Objection to Planning Application AW/197/20/PL

Planning Application AW/197/20/PL The former Ship Inn Variation of Conditions applied to previous Planning decision AW/211/14/PL

Client
Surplus Property Investments
 Project
The Former Ship Inn, Aldwick Street, Bognor Regis. PO21 3AP
 Title
Highway details with Vehicle Tracking : Articulated Delivery Vehicles

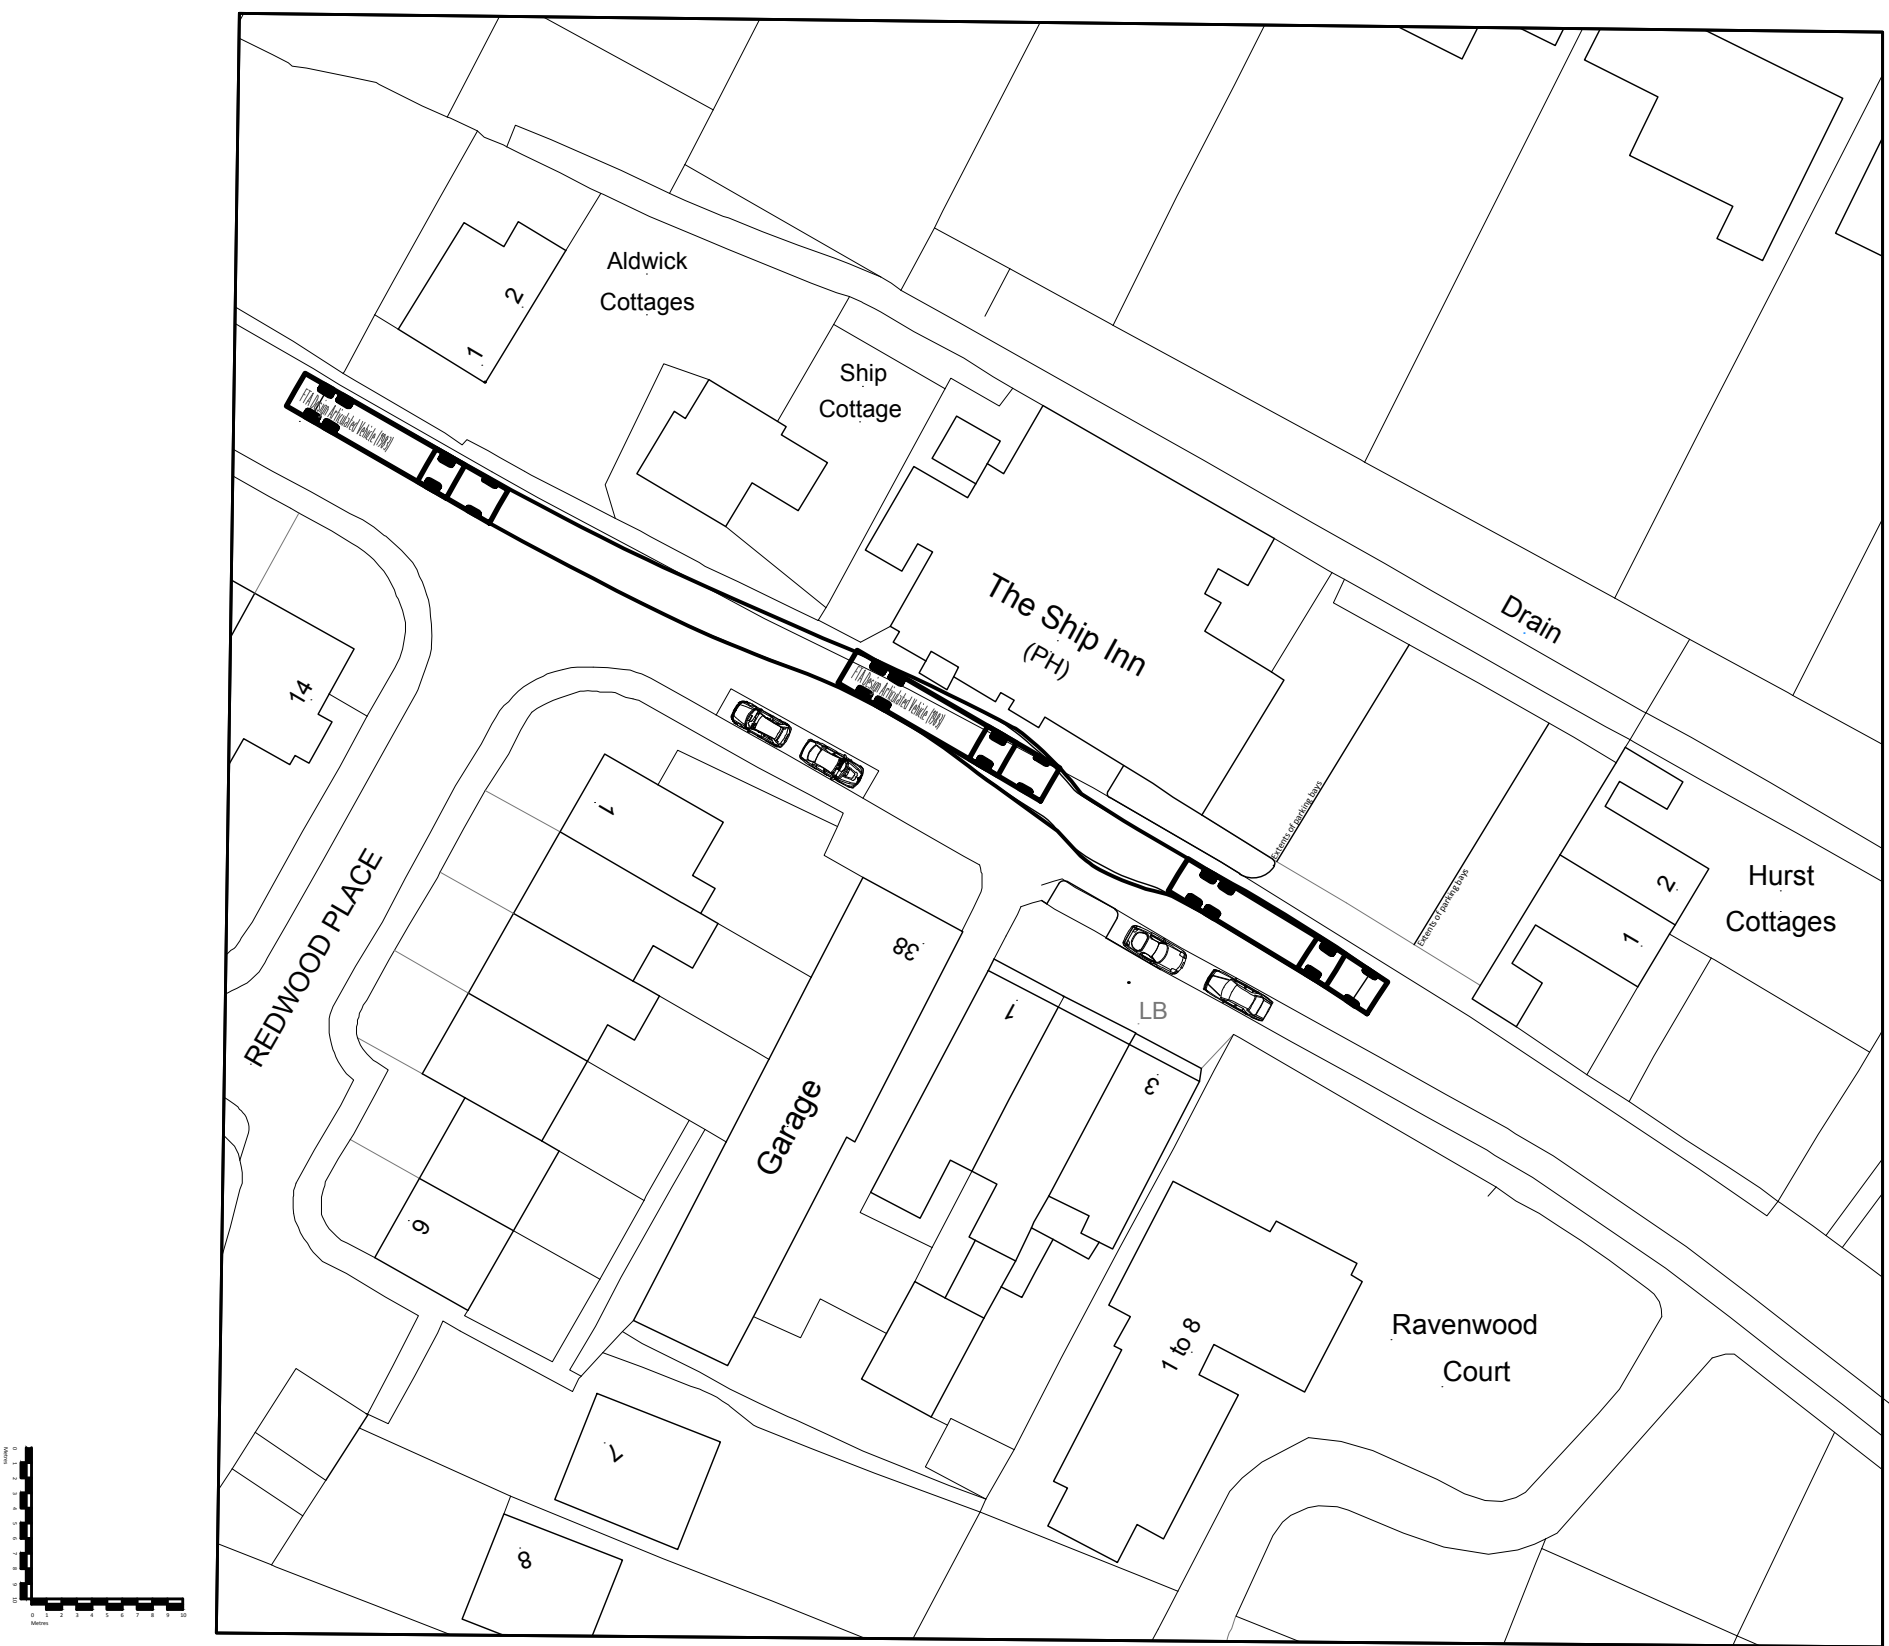
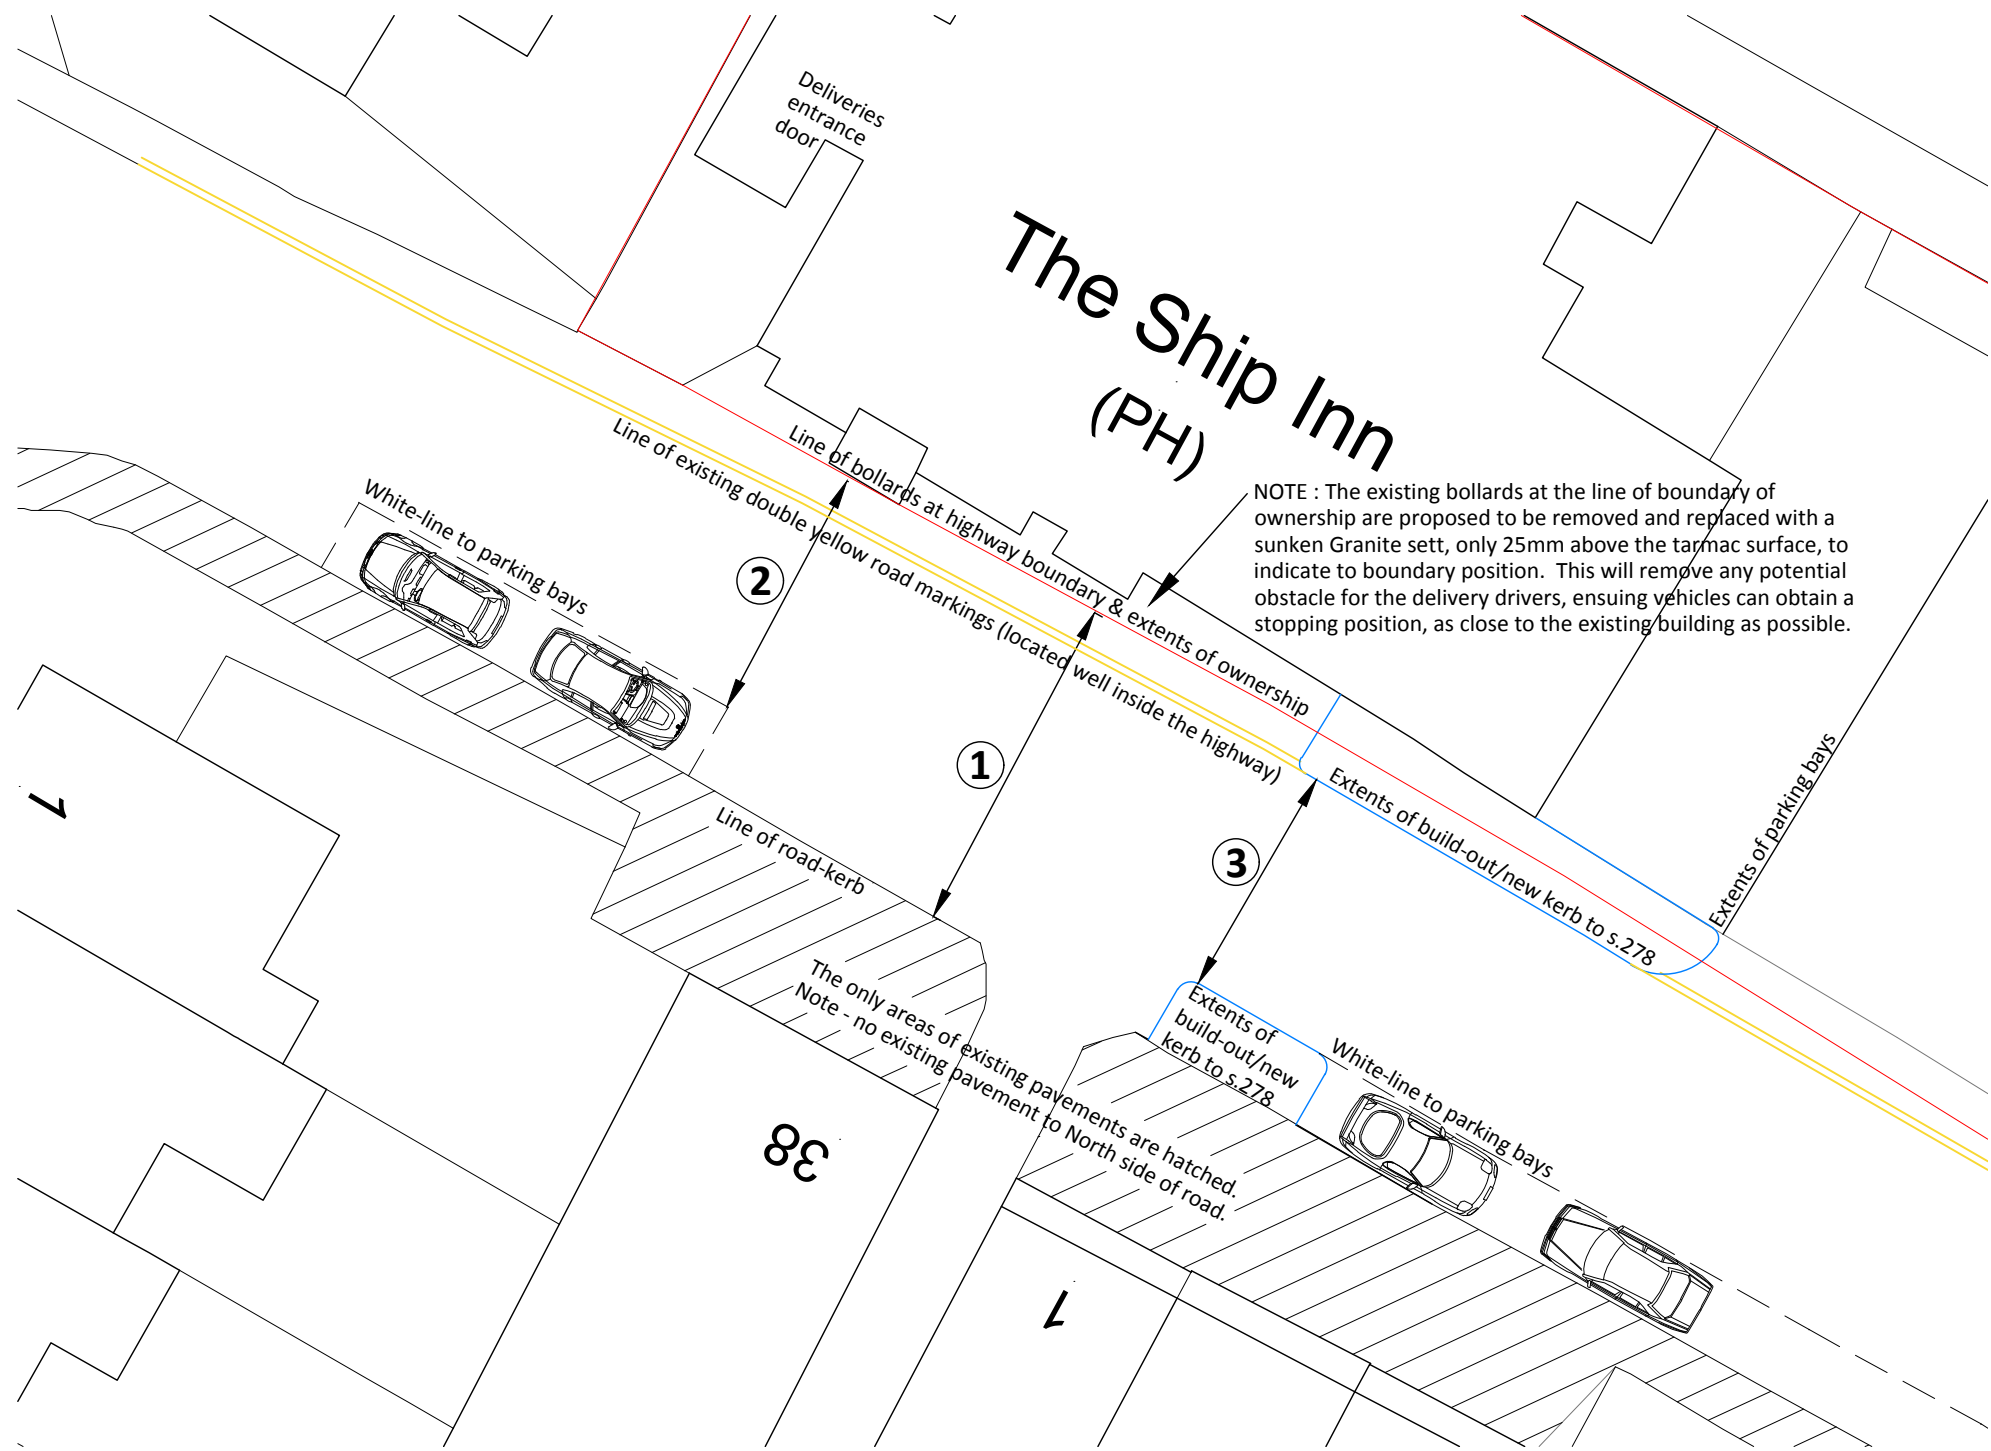
Notwithstanding the comment in drawing B200038 B202 that the existing bollards would be removed to give the delivery driver more space to pull off the highway, such a manoeuvre would restrict the space available for the delivery driver to unload his payload safely. Access will still be hindered by the posts supporting the porch roof.

The goods would have to be unloaded and taken to the entrance in the existing car park and where the bin store is located. Both swept path plans submitted show rigid and articulated delivery vehicles parked on the carriageway with rear access to the North West (ie the vehicle approaching from the Barrack Lane/ Aldwick Road junction with Aldwick Street. With the vehicle in this orientation, the delivery operatives would be obliged to push the loaded and empty trolleys past the parked vehicle on the carriageway side to the car park and from the bin store shown on the original submission plans.
